Recommendation Report for Planning Permission for Works or Extension to a Dwelling**REF NO:** FG/152/24/HH**LOCATION:** The Old Flint House
Church Lane
Ferring
BN12 5HR**PROPOSAL:** New 3 bay carport. (This application may affect the character and appearance of the Ferring Conservation Area).**SITE AND SURROUNDINGS**

Dwg. No. P-003A
Title: Proposed Elevations
Address: The Old Flint House, Church Lane, Ferring, BN12 5HR
Client: Mr and Mrs Bush
Scale: 1:50@A3
Stage: PLANNING
Drawn: PS
Date: Dec 2024

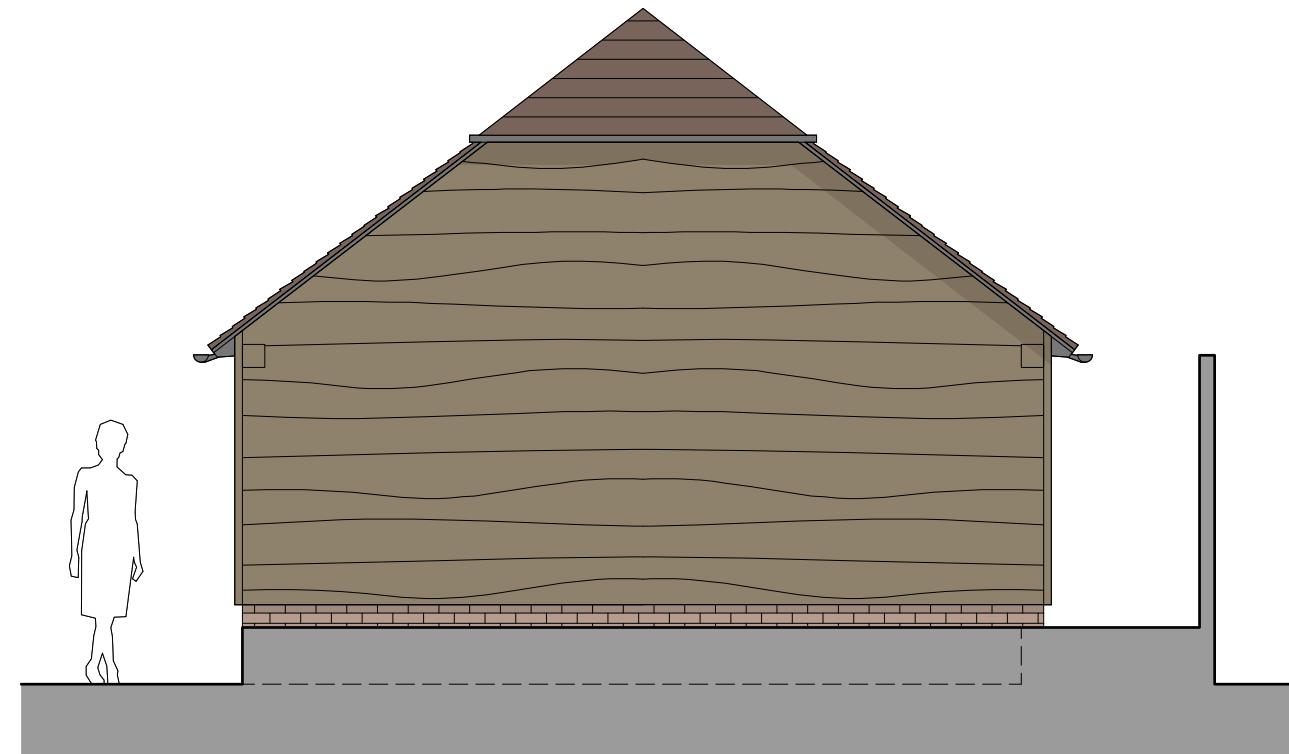
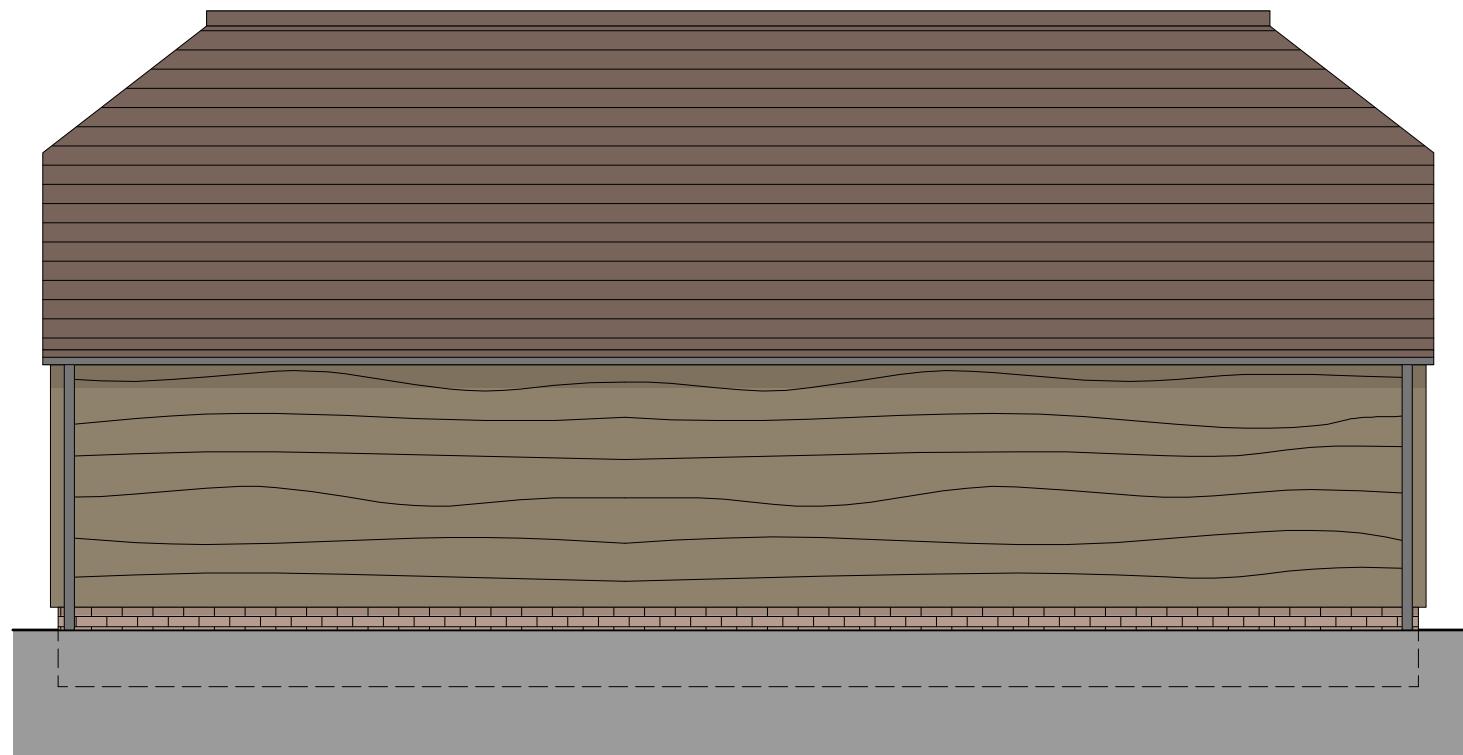
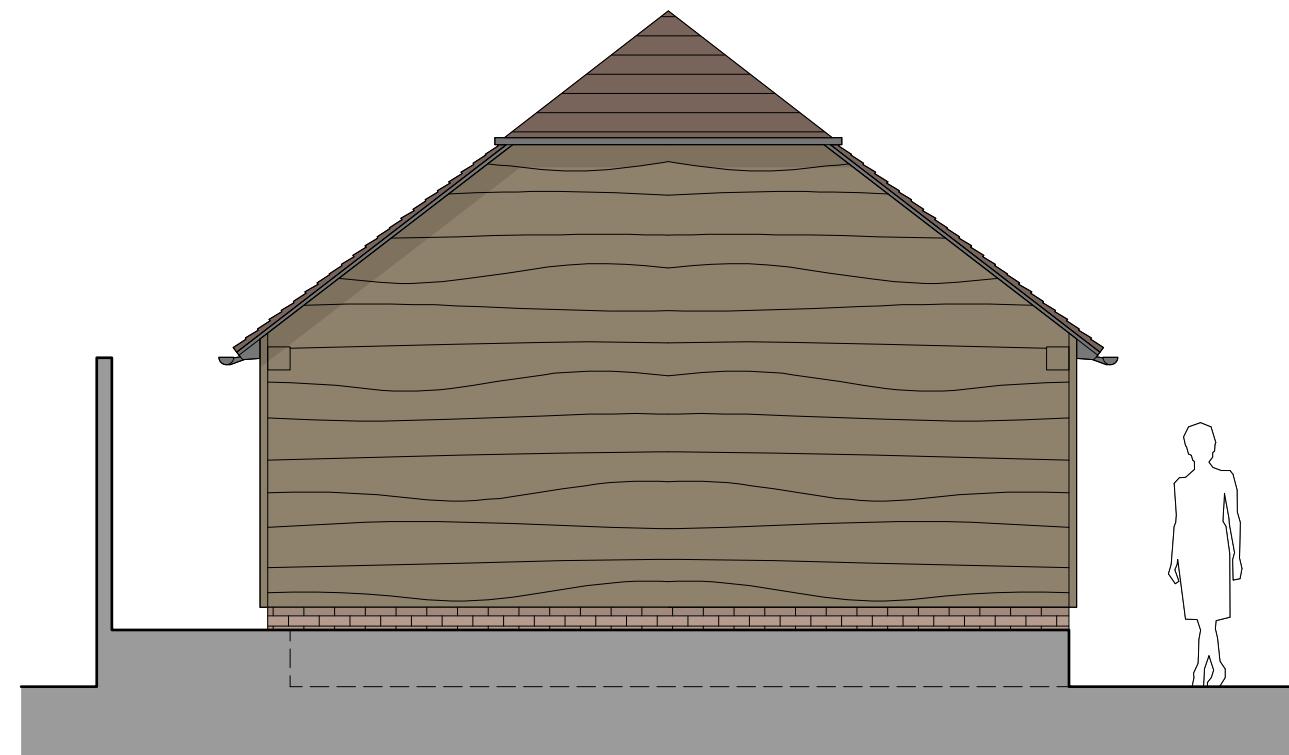
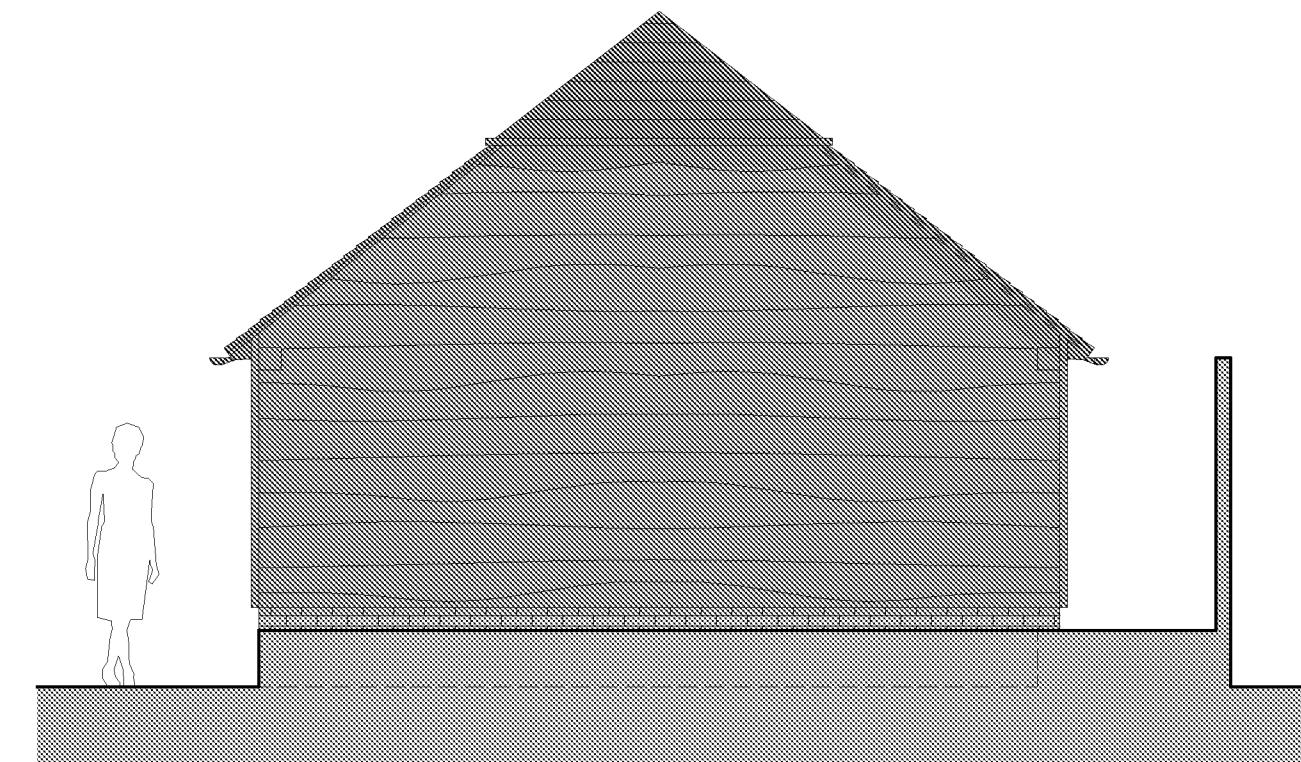
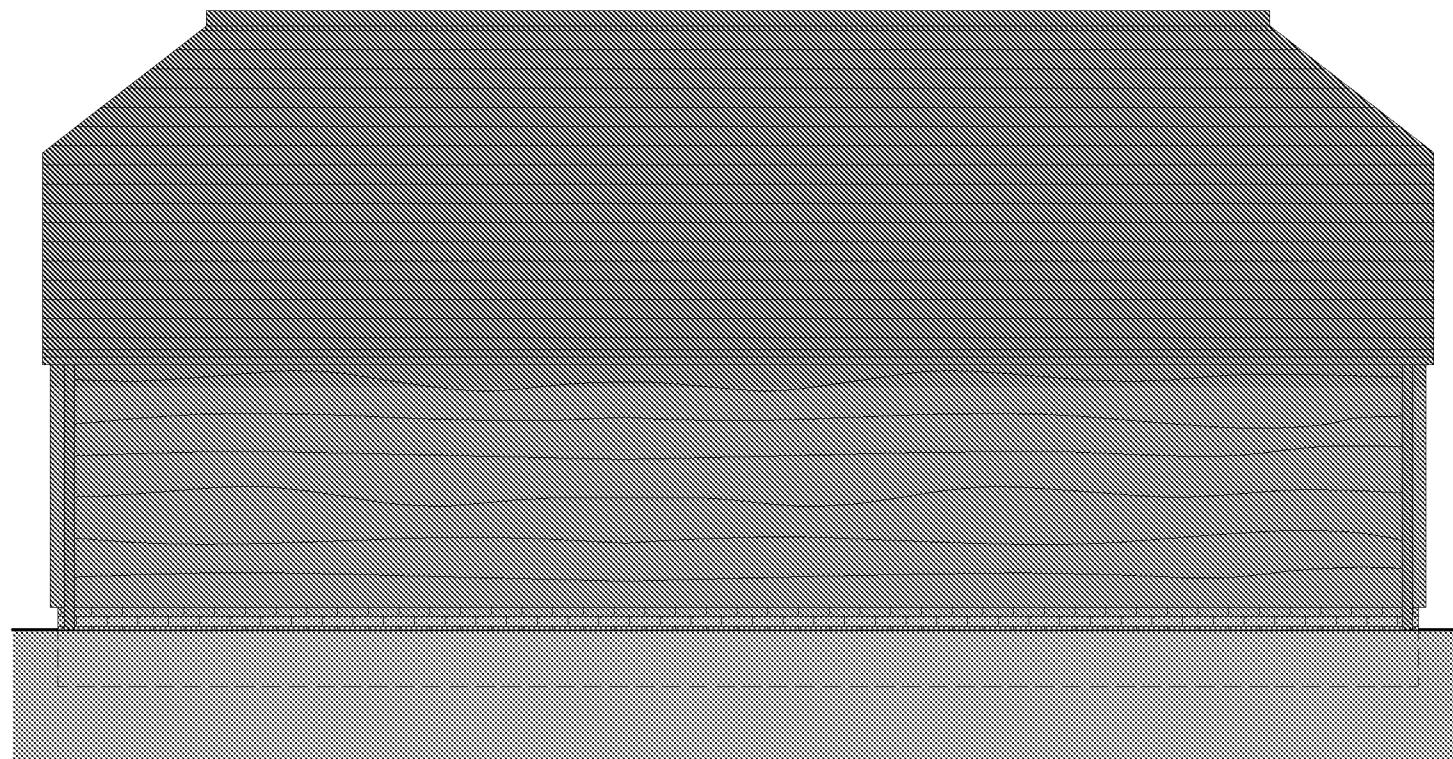
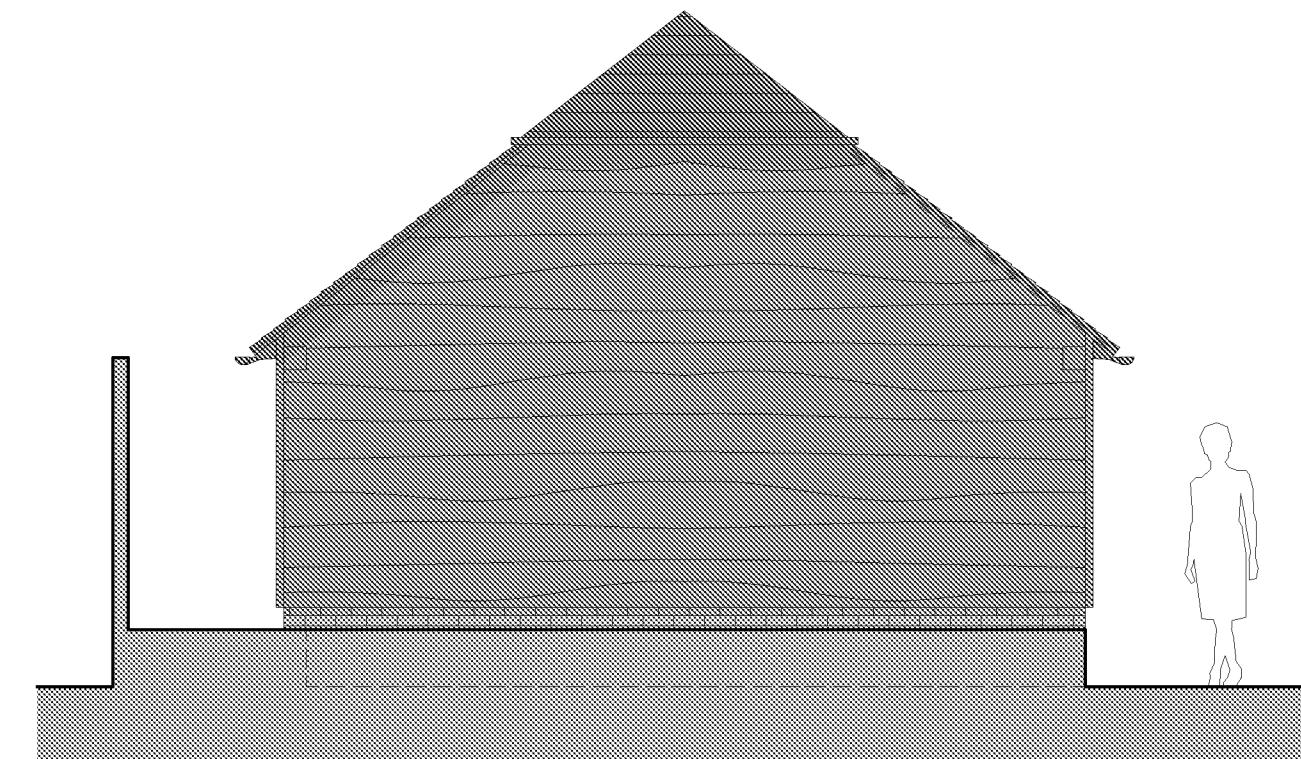
It should be noted that the elevations shown do not match in regard to the height of the building.

Comments noted. A suitably worded informative has been added to address the removal of bushes to the south (side) corner of the property and amended elevations have been submitted.
